Your Ref: OWPC21760
Our Ref: AW/28/19/PL 22-01-2019
Please ask for:
Mr S Davis

Erection of 1 No. dwelling & associated works.

Rear of 276 Aldwick Road Aldwick

Location Plan
Scale 1:1250

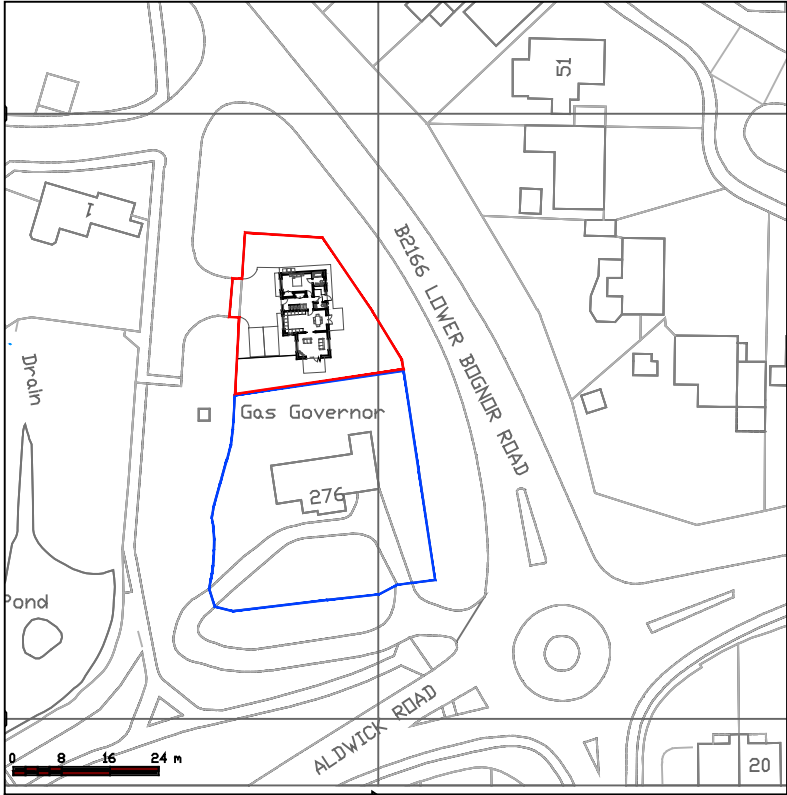
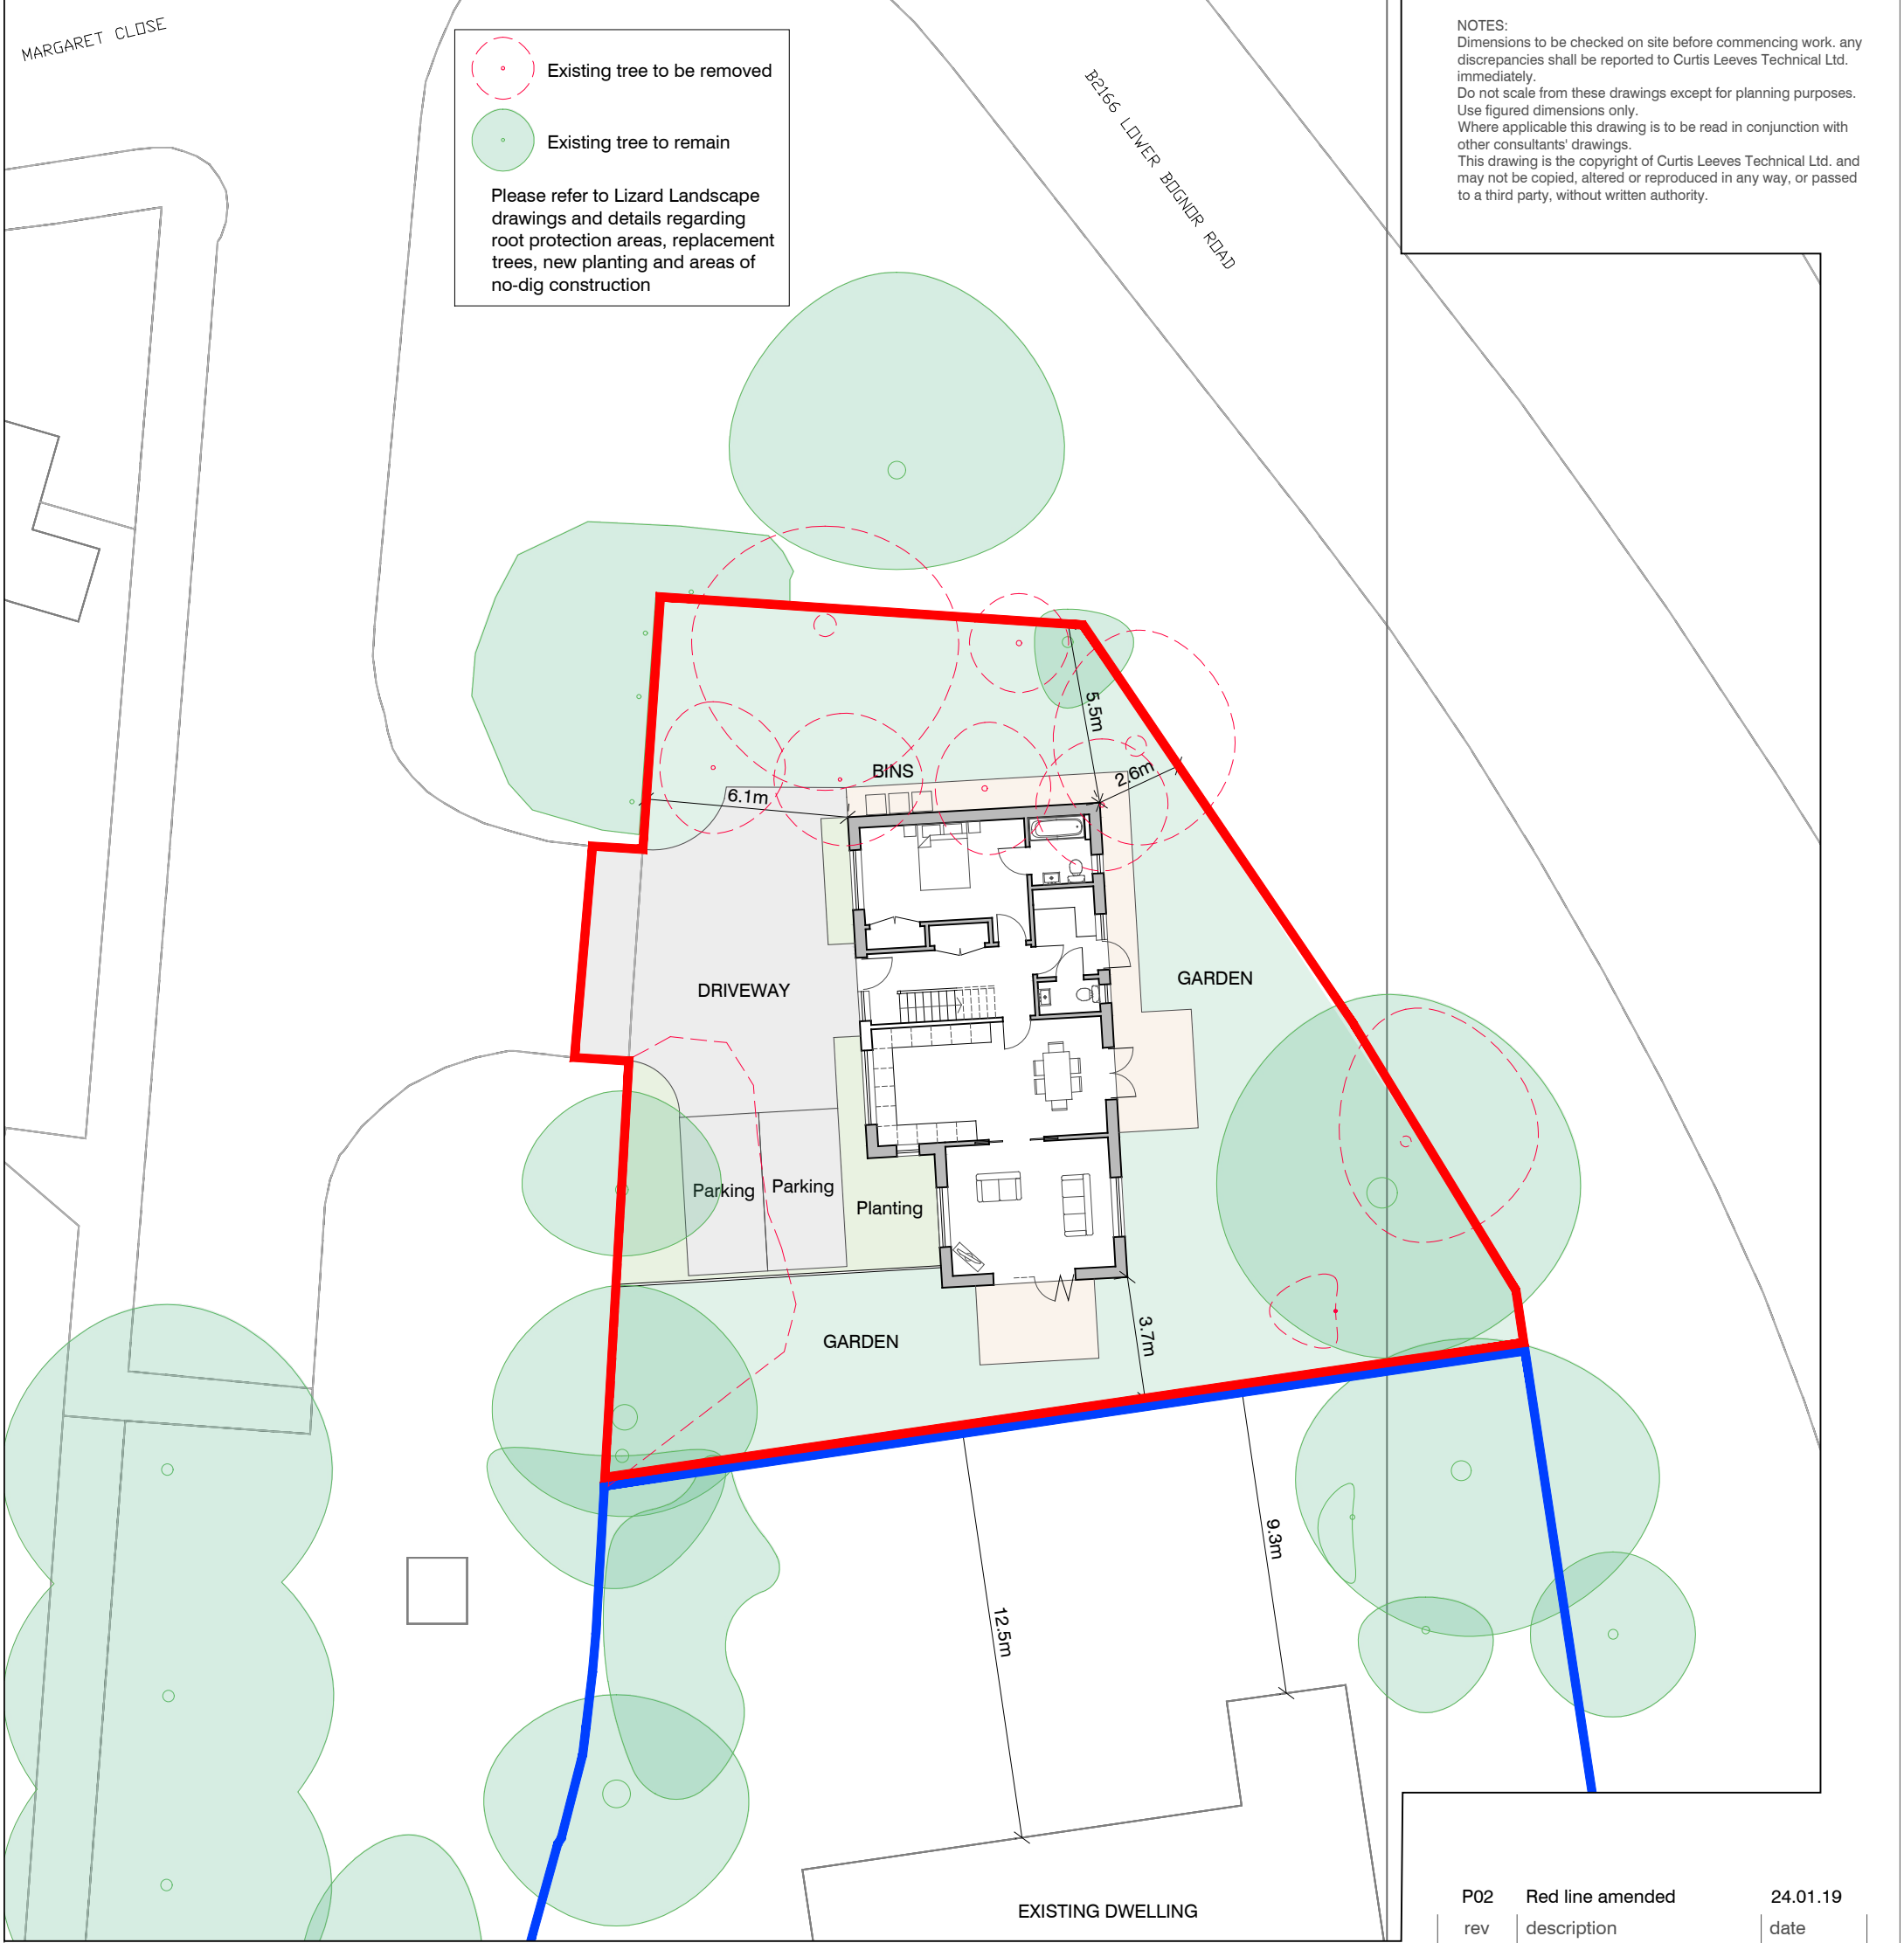
Regarding the proximity to the Aldwick Duck Pond, the site for development is just 50m from this amenity location. Shouldn't this be more clearly shown on site plans? As they are currently drawn, the small inset Location Plan makes the pond appear further away than it is, by labelling the island in the middle of the pond as the pond!
